Subdivision Comments

From: Dan Suggs, Environmental Health Specialist II

RE: SP-24-00010 Fahlgren

FAHLGREN SHORT PLAT PART OF SECTION 5, T. 17 N., R. 18 E., W.M. KITITAS COUNTY, WASHINGTON

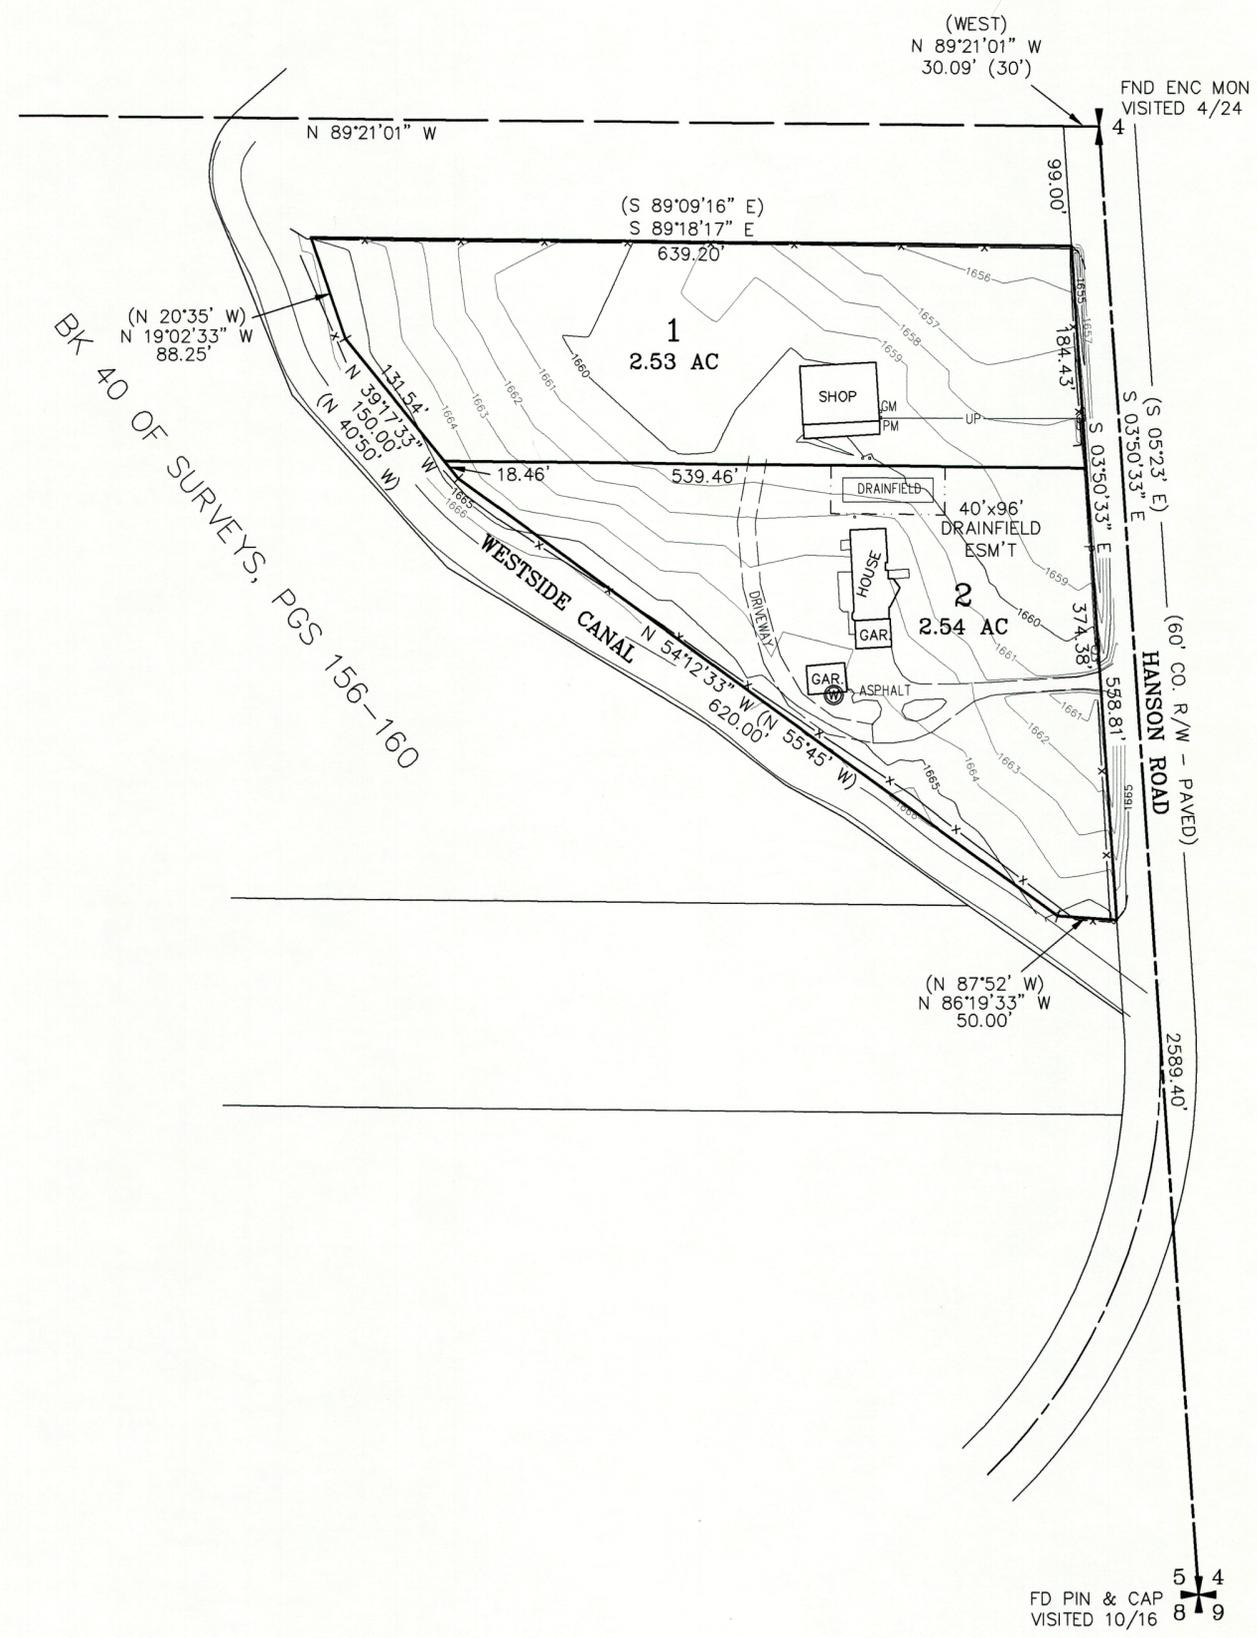
The applicant intends to use the existing individual well on lot 2 to be utilized as a shared with lot 1.

-
- KCC13.20.040 (5) A well for an individual/shared water system shall also be located:
 - All individual and shared wells must be placed a minimum of fifty feet from all roads and property lines.
 - Setbacks not meeting Kittitas County Code may be allowed at the discretion of the health officer.
- KCC 13.20.050 (3) If any existing wells are included as part of a subdivision or building permit application, the well shall comply with all current state and local regulations, or the well shall receive approval from KCPHD to be exempt from current regulations.
- A minimum of one soil log dug to a depth at least 48 inches on lot 1 must be recorded with

- A shared well users agreement signed by both users of the well that is recorded with the County Auditor.
- A well log recorded within the last ten (10) years demonstrating a minimum flow of five (5) gallons per minute (GPM) for at least a two (2) hour period shall be submitted to KCPHD.
 - If a well log is not available or the well log indicates a flow of less than five (5) GPM for the two (2) hour period, then a four-hour draw down test shall be submitted to KCPHD.
 - A well log that was recorded more than ten (10) years ago may be accepted at the discretion of the Health Officer.
